PR-2019-002309

MINOR_PLT-2025-00016 – PRELIMINARY/ FINAL PLAT

REQUEST: Minor subdivision of 1 Existing Lot into 2 New Lots

Request: Minor Preliminary Plat and a determination to forgo the requirements of the DPM landscape buffer in Table 7.2.29

SHEET 3 OF 3

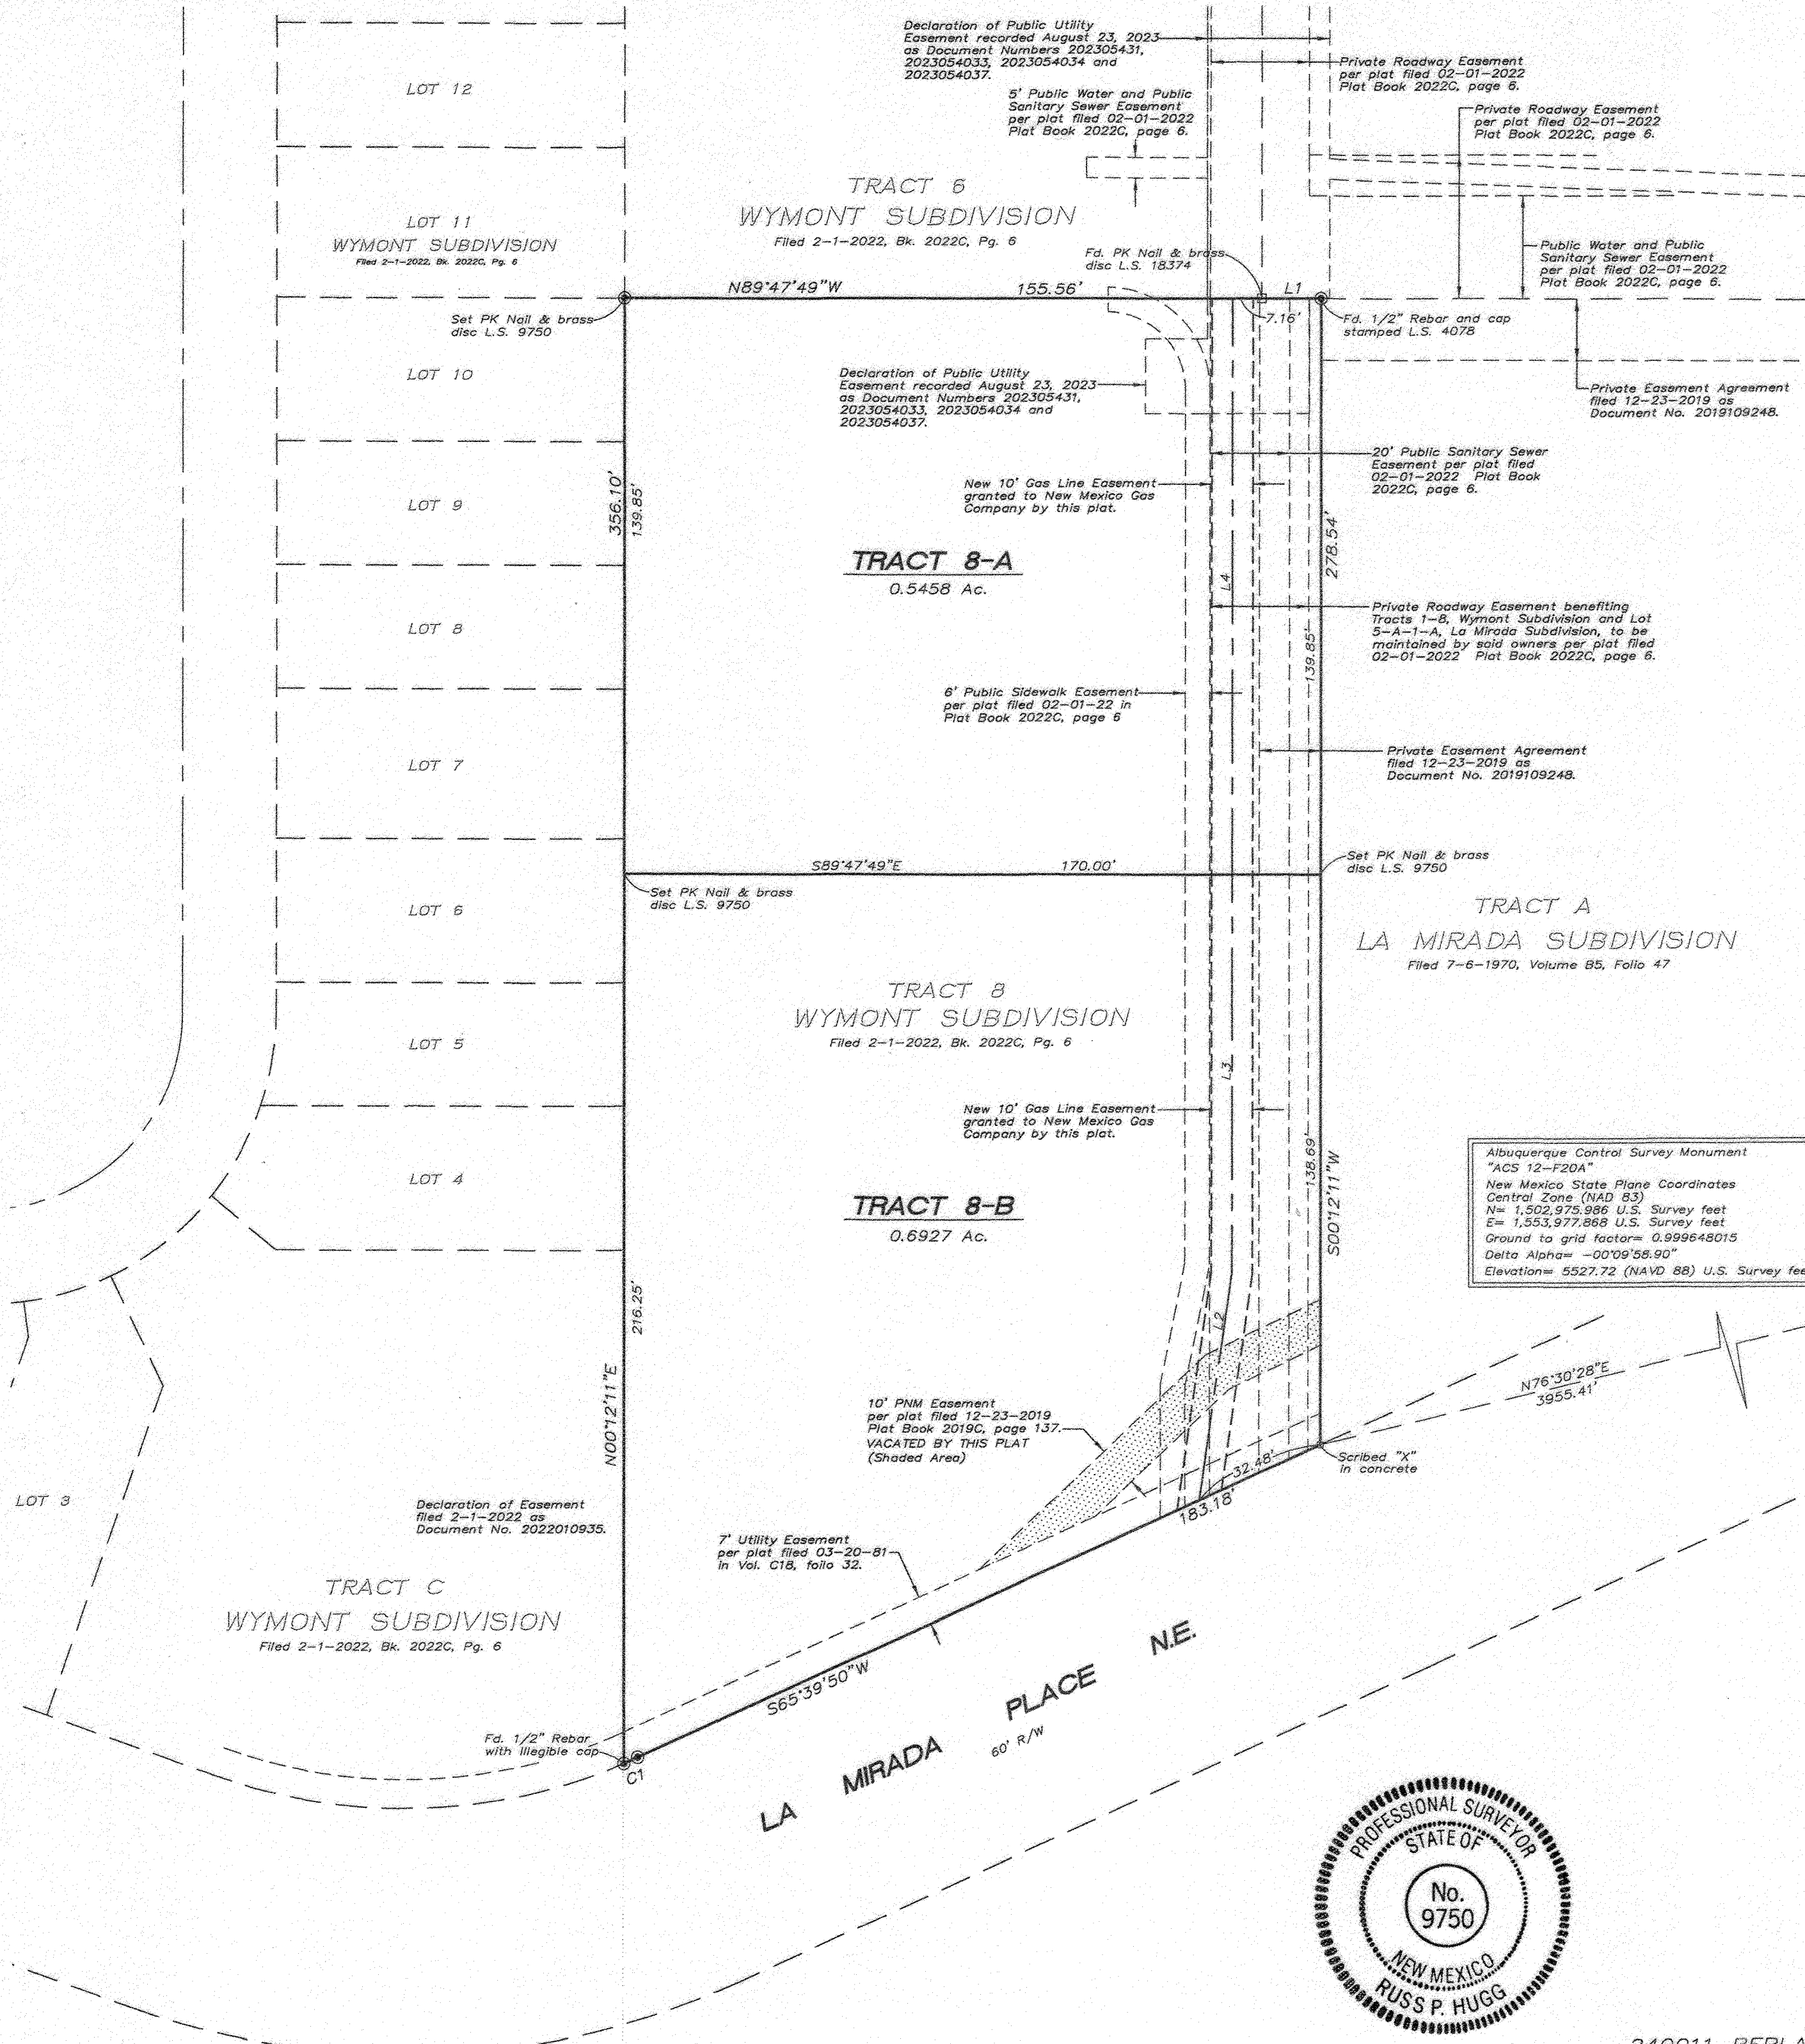
- The required signatures from the surveyor, property owner(s) and the City Surveyor for a Minor Preliminary Plat are on the Plat.
- Project and application numbers must be added to the Plat.

- Planning defers to Transportation regarding the determination request and its compliance with the DPM.
- A note must be added to the Plat recorded the request (approval) of this determination from the DHO.
